Recommendation Report for Planning Permission for Works or Extension to a Dwelling

REF NO: **FP/144/12/**

LOCATION: 39 Davenport Road
 Felpham

PROPOSAL: Proposed new garage, shower and utility room (resubmission following FP/48/12/)

Drawing 3 / 4

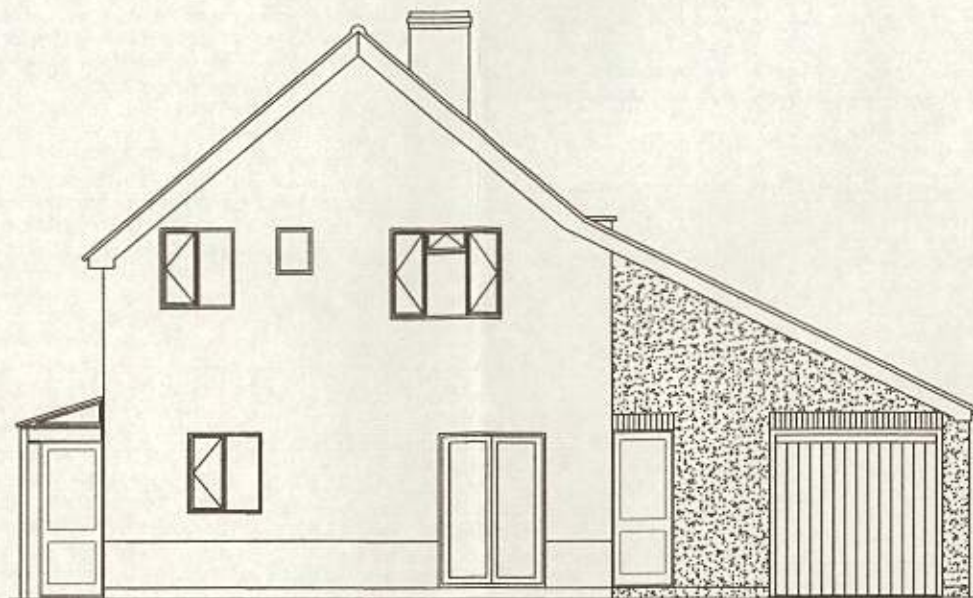
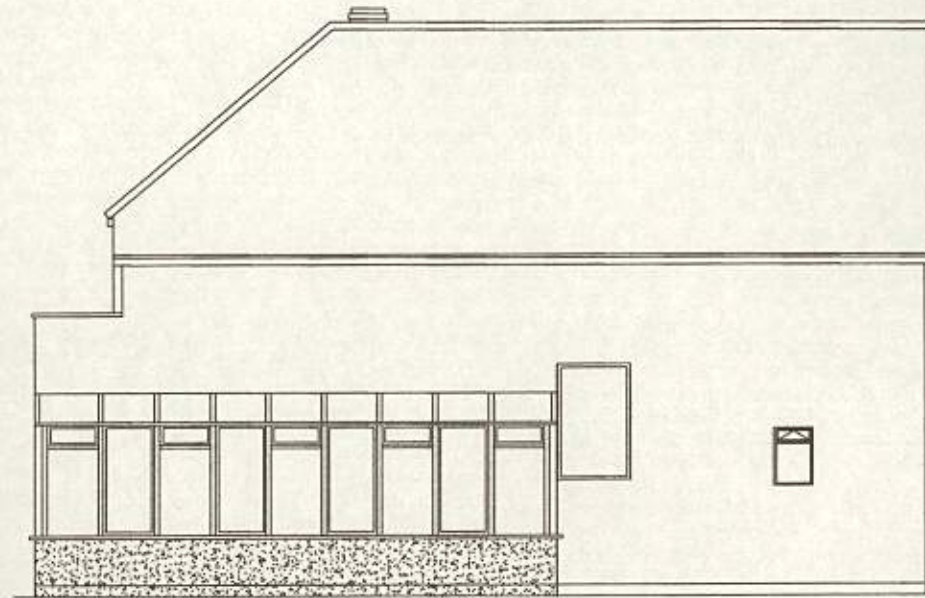
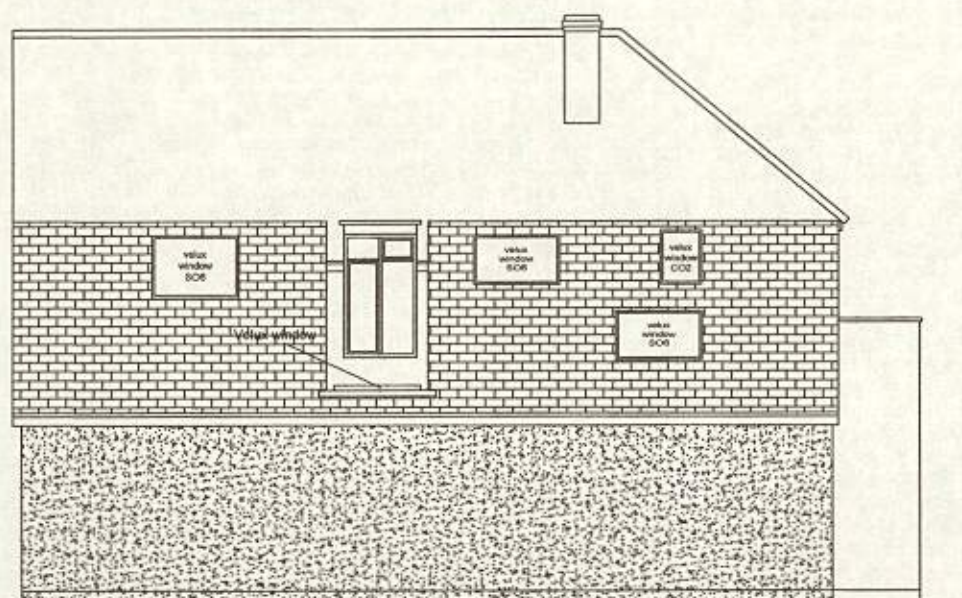
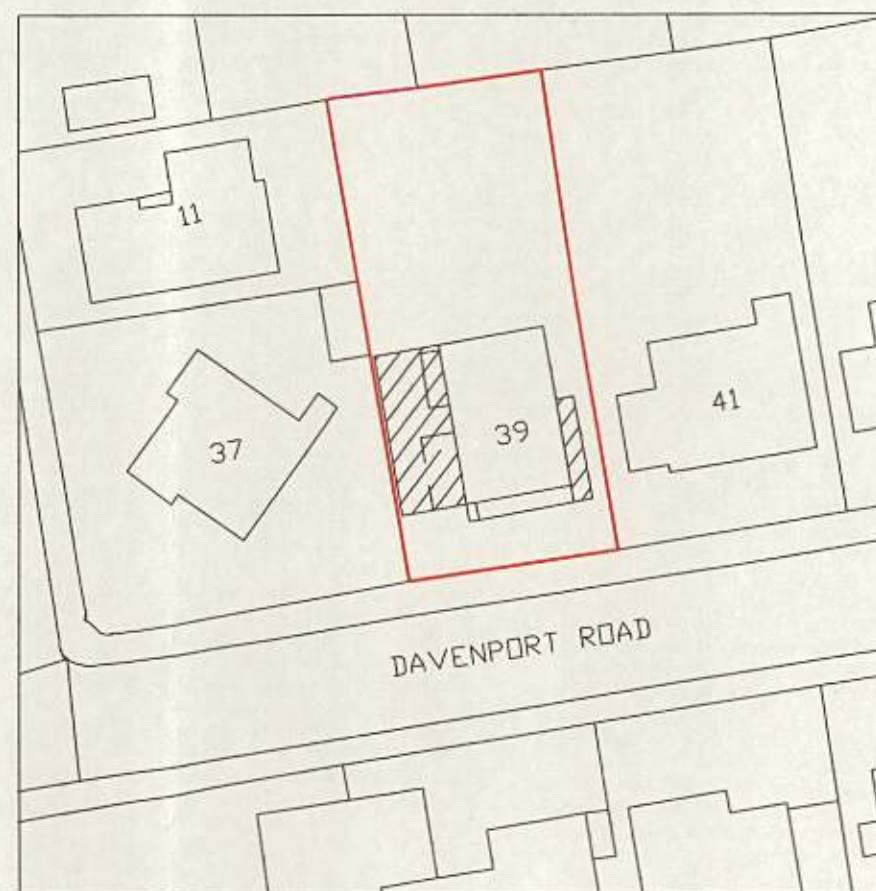
The current proposal follows negotiation. The depth of the proposed extension is reduced by 1 metre and the extension will be set in 150mm from the side boundary adjoining no. 37. The ridge height of the proposed extension will be in line with the eaves height of the property and the front elevation set back 1 metres from the front elevation of the host property. The extension will be faced in block and render with plain roof tiles under a mono pitch roof to match the host dwelling.

On balance, the revised scheme is considered to be less visually obtrusive within the streetscene and the surrounding area at this reduced depth and scale. Further, it is noted that side integral garages are a feature of the surrounding streetscene; a similar side extension was approved at no. 25 Copeland Road in 2007 (FP/1/07).

The previous scheme was found to have no adverse impact on the residential amenities of the neighbouring property to the west at no. 37 Davenport Road by way of overlooking or loss of privacy and daylight. The roofline of the proposed extension will be hipped away from the side boundary and a gap of 150mm will be retained to the common boundary. The rooflights will serve a garage/utility room/bathroom. They are at an angle and positioned high in the roofslope. It is therefore considered that there will be no unacceptable loss of amenity to the neighbouring property.
